Waterfront Construction, Inc.

3.6.2023

Cover Letter – Response to SHL22-029 (Keller Pier Repair) Request for Information #1

PROPOSED SITE PLAN DETAIL

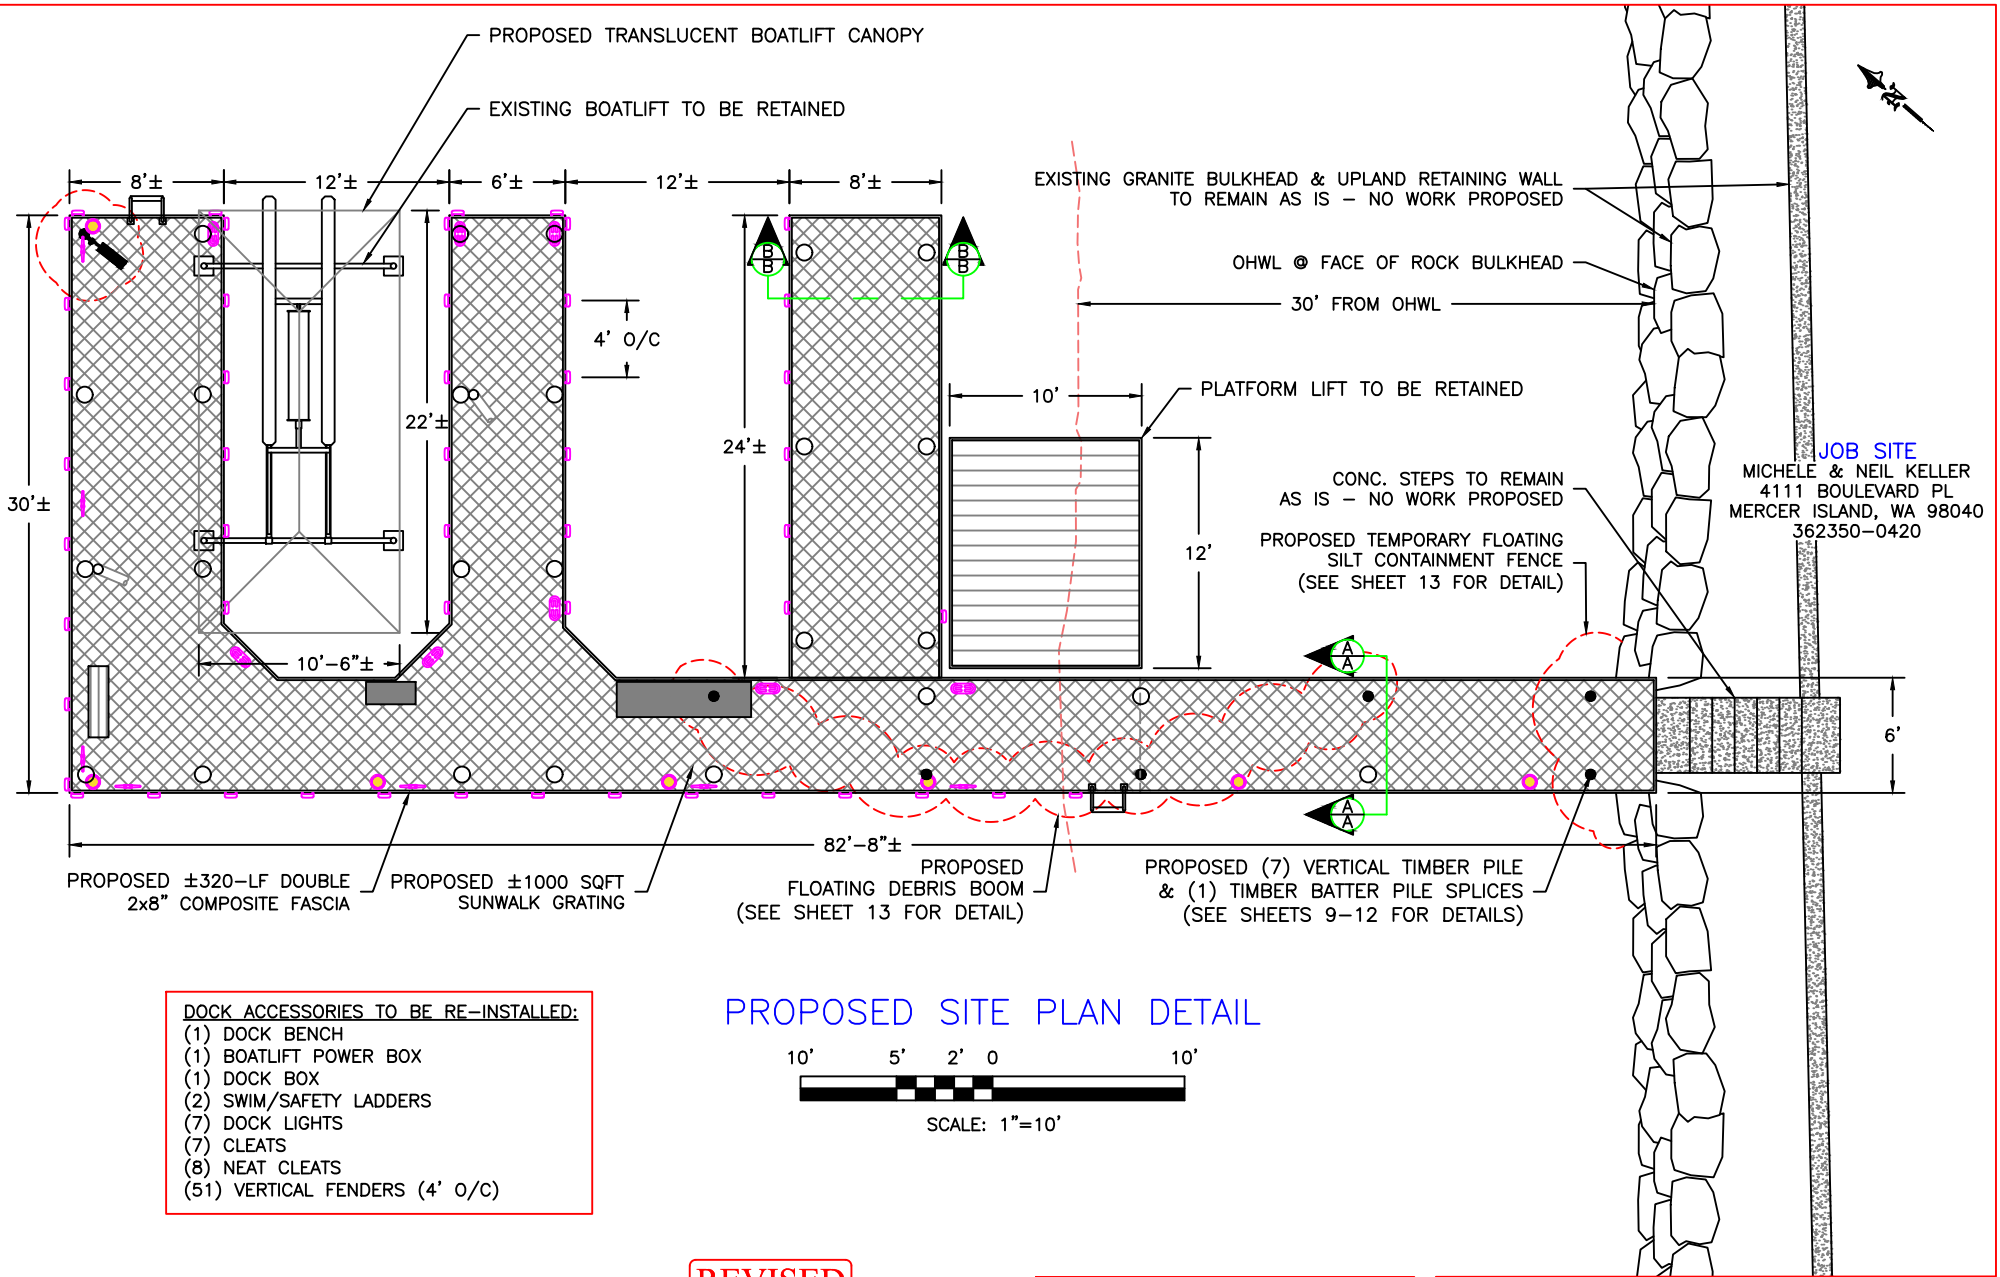
4. MICC 19.13.050(F)(2)(ix) states that the structural repair that results in the repair of more than 50% of the structure's framing elements within a 5-year period shall comply with the review criteria in MICC 19.13.050(F)(2)(ix)(a) through (c). Please provide an accounting of the pier's framing elements that are proposed to be repaired compared to the total number of framing elements. If more than 50% of the pier's framing elements are proposed to be repaired, please demonstrate how the standards of MICC 19.13.050(F)(2)(ix)(a) through (c) are being met.
WCI Response: The pier's total number of existing framing elements are 35 piles, 861 lineal feet of stringers and 196 lineal feet of cap beams. 8 piles (22%), no stringers (0%) and no cap beams (0%) will be repaired. Please see revised plan set dated 2.21.2023, sheets 5 and 6 for details.

PROPOSED SECTION A-A

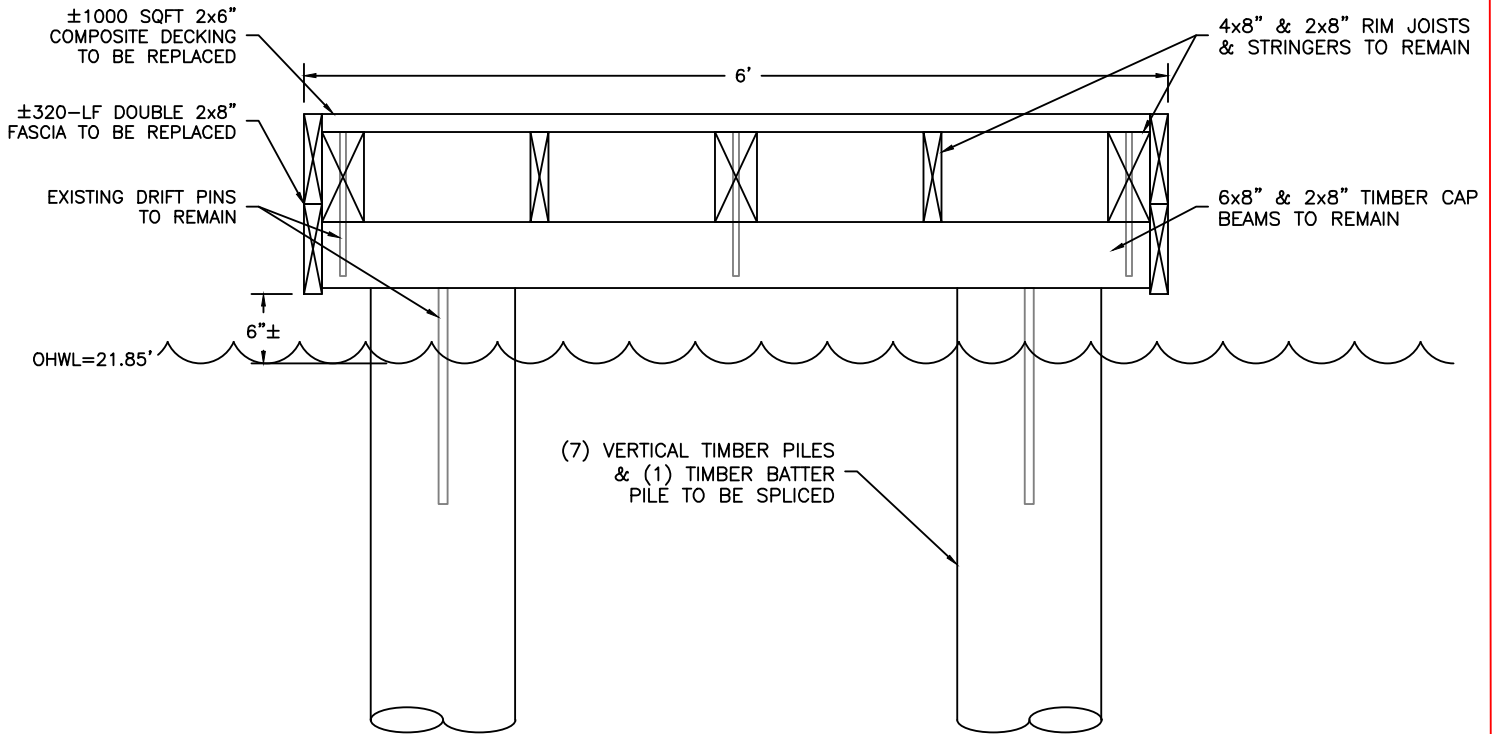
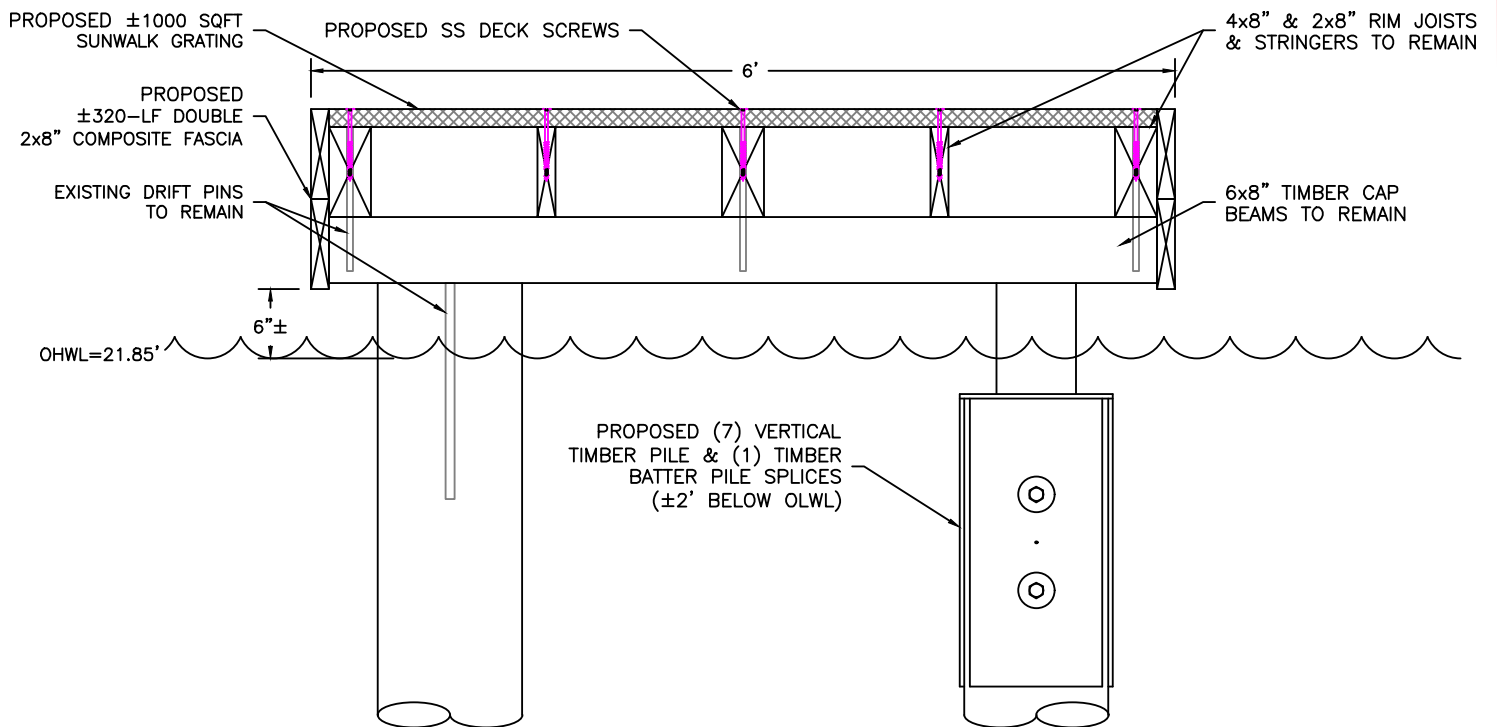
5. MICC 19.13.050(F)(2)(x) and (xi) state that any decking that is removed in the course of repair shall be replaced with decking that allow a minimum of 40% light transmittance. Please verify that the proposed grated decking will allow light transmittance of at least 40%.
WCI Response: The grated decking proposed is SunWalk decking, SunWalk 45 Series, which has a light transmittance of 43%. Please see attached for SunWalk 45 Series Specs & Product Dimensions sheet.
